Town & Country Planning (Control of Advertisement) (England) Regulations 2007 (as amended)

Application for Consent to Display an Advertisement(s)

Development: See Application Form
Location: Lidl Foodstore Oldlands Farm Steyning Way Bognor Regis PO22 9NN

PROPOSED SITE PLAN  
SCALE 1:500

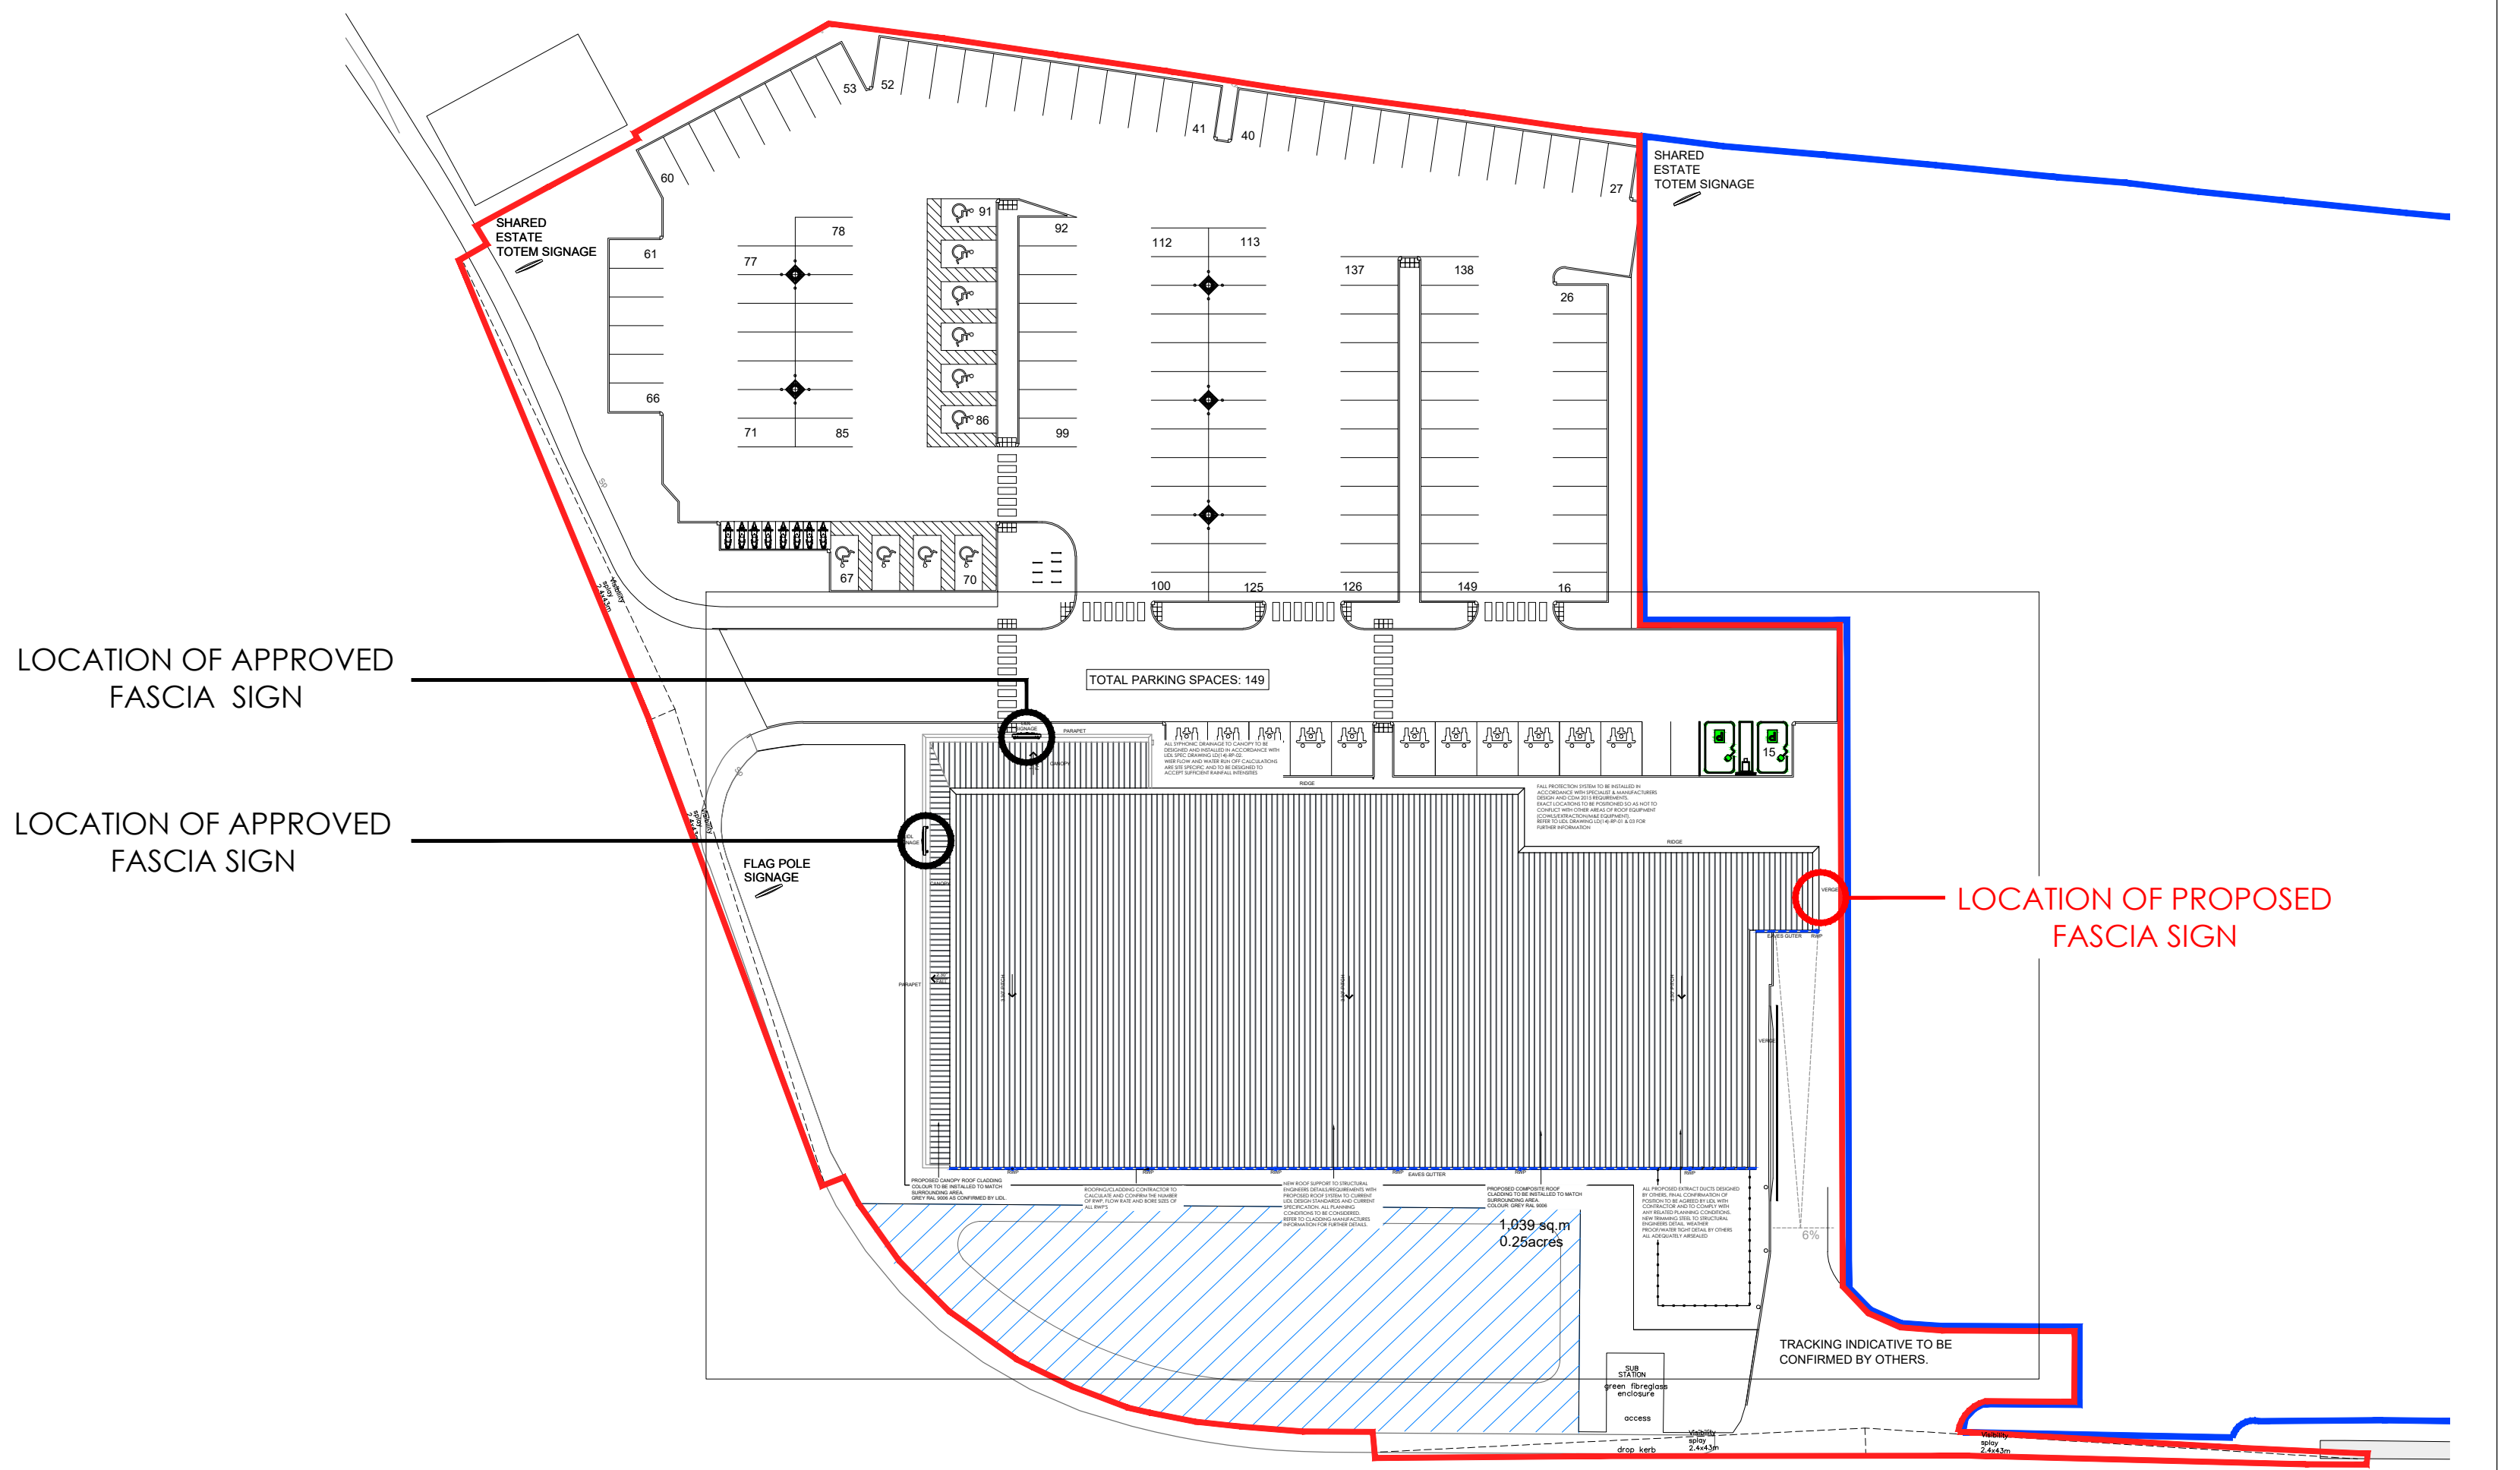
For clarity, please confirm the number of fascia signs you are applying for. The site plan shows 3 signs, however the application form has been completed as 1.
